**Project# 1010222**

14DRB-70309– SITE DEVELOPMENT PLAN FOR SUBDIVISION  
14DRB-70311 MINOR - PRELIMINARY/ FINAL PLAT APPROVAL

DEKKER PERICH SABATINI and SURV-TEK INC agents for CARR REAL ESTATE LTD request the referenced/ above actions for Lot 15, **LOOP INDUSTRIAL DISTRICT Unit V**, zoned SU-2/M-1 or C, located on the southeast corner of JEFFERSON ST NE and WILSHIRE AVE NE containing approximately 3.3594 acres. (C-17)

CITY OF ALBUQUERQUE  
 PLANNING DEPARTMENT  
 DEVELOPMENT REVIEW BOARD

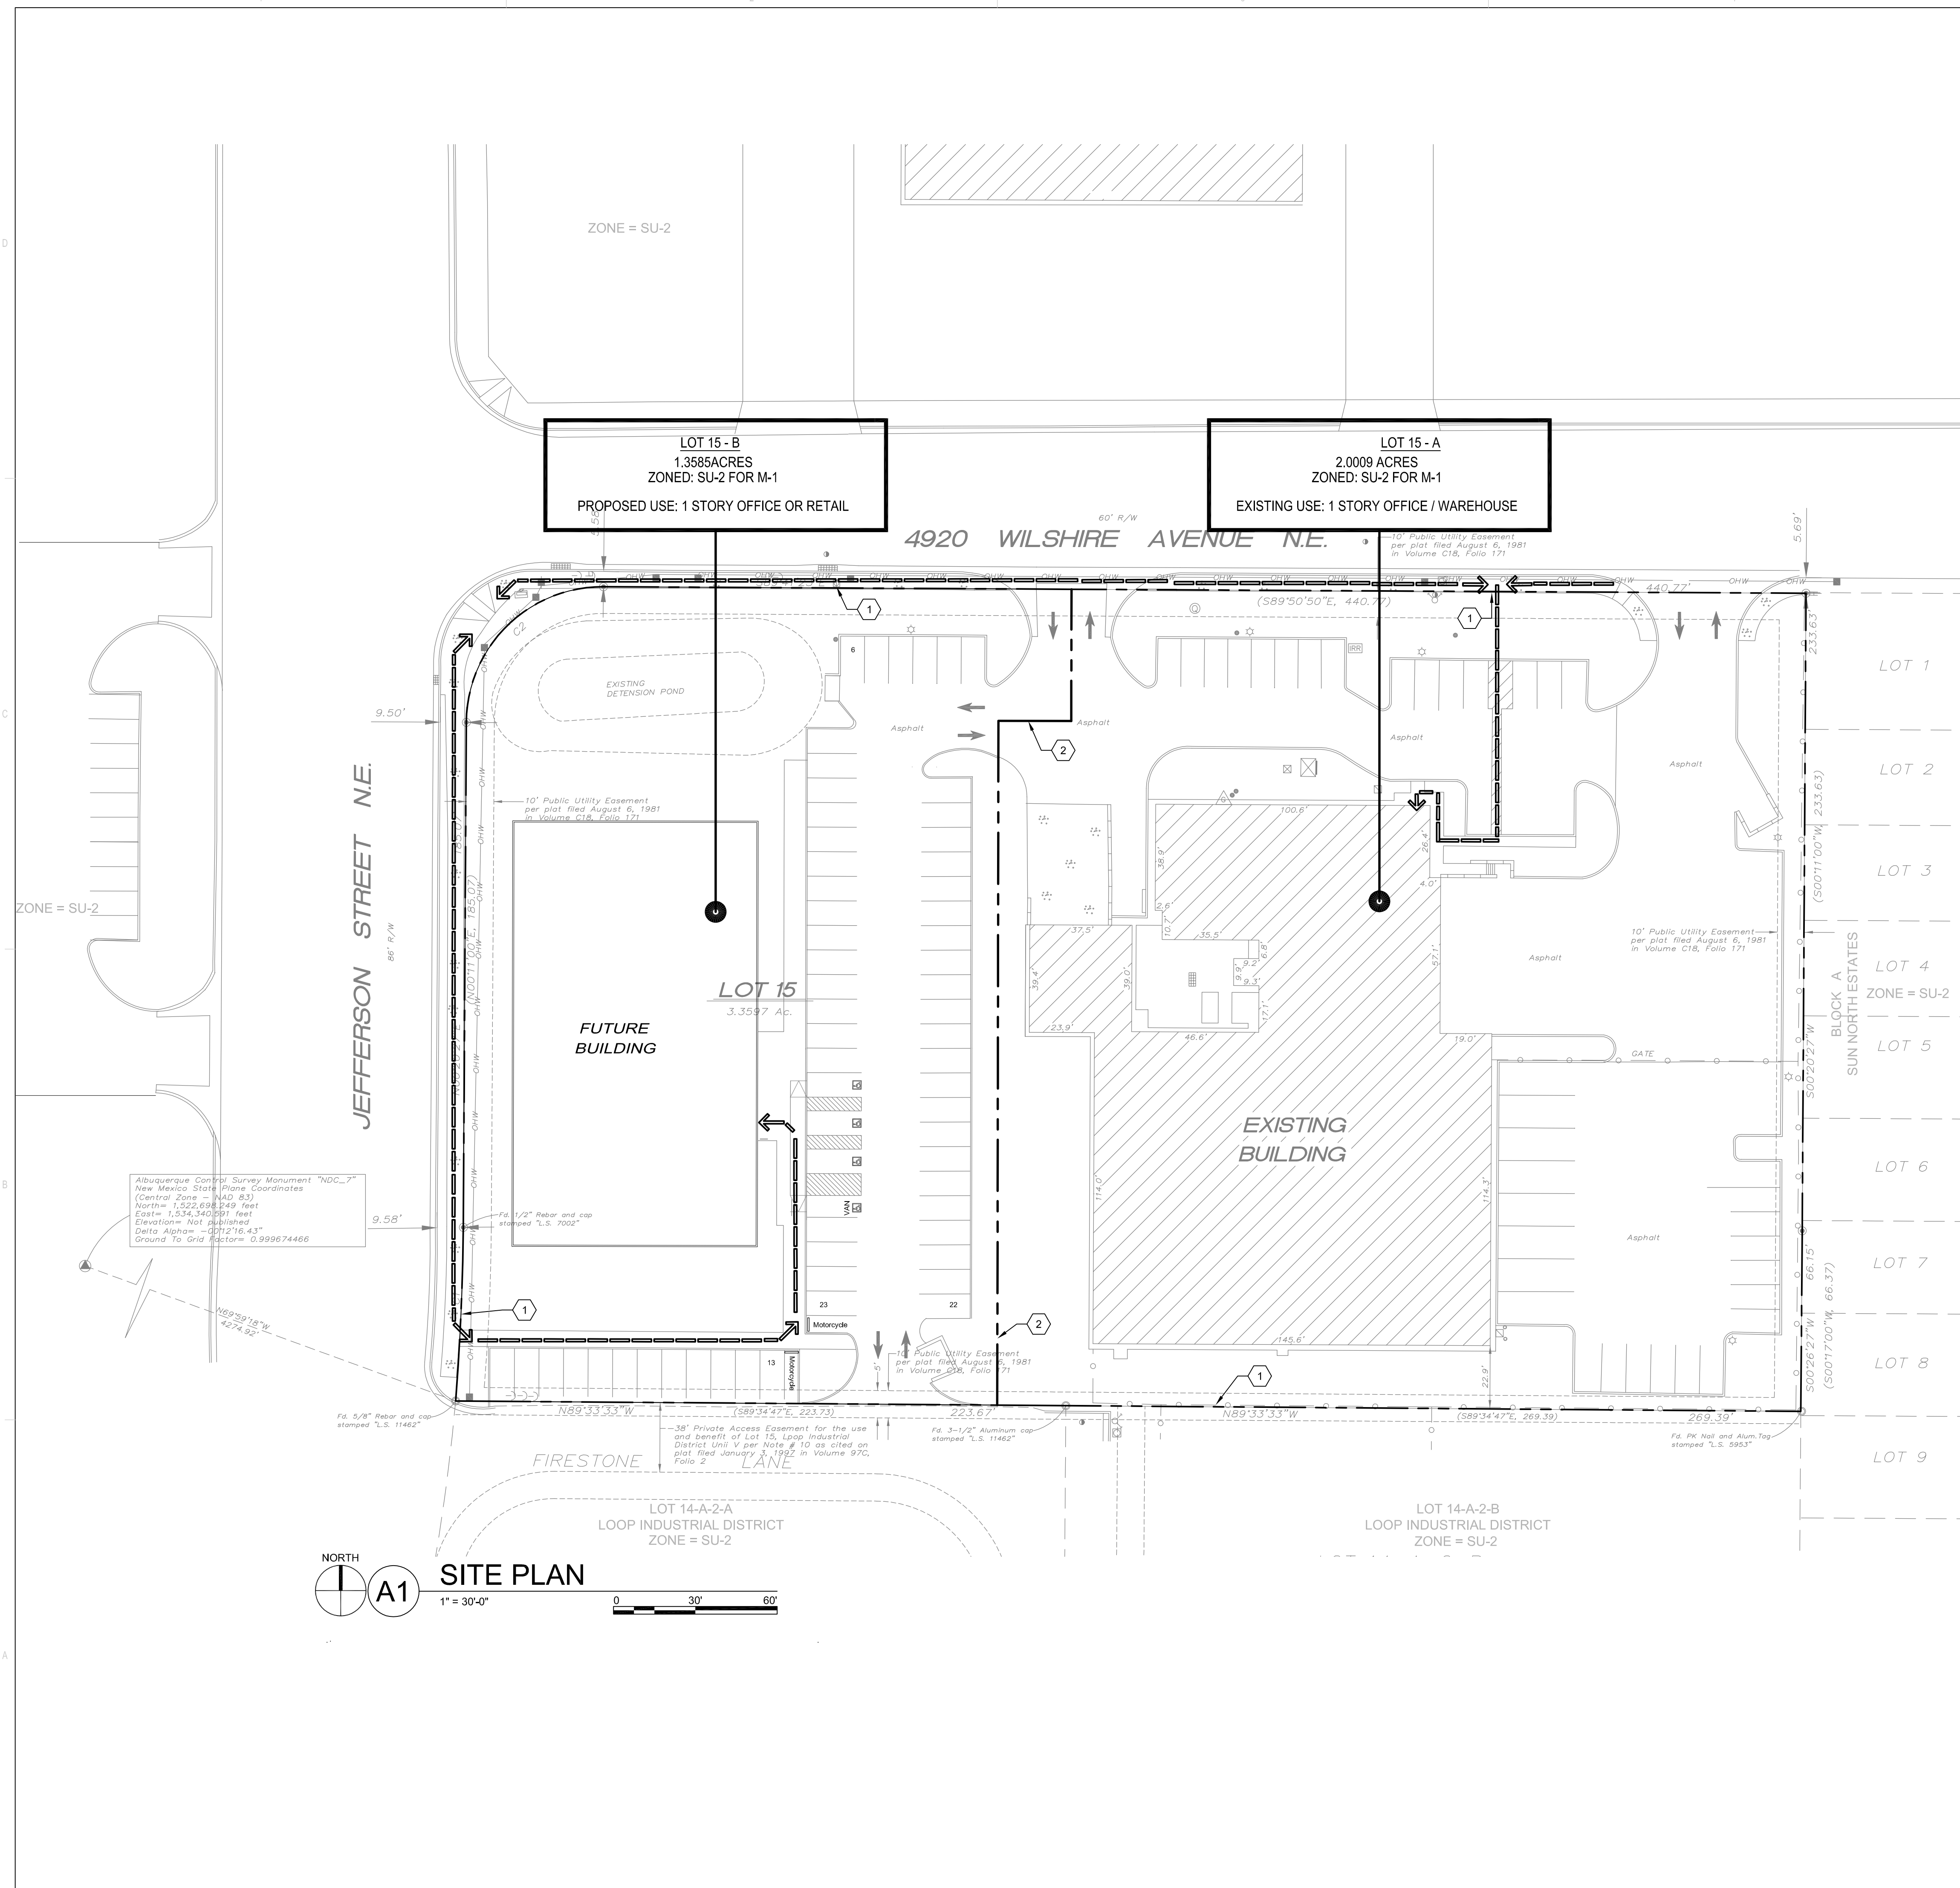
Per the MGCOCG-Adopted Interim Long Range Roadway System map and the Long Range Bike System Map, Jefferson St. is minor arterial proposed to contain on-street bike lanes along this site's frontage. It is not clear from the scanned site development plan provided what the existing R/W width is for Jefferson St. or if a northbound bike lane is accounted for along the site's west frontage.
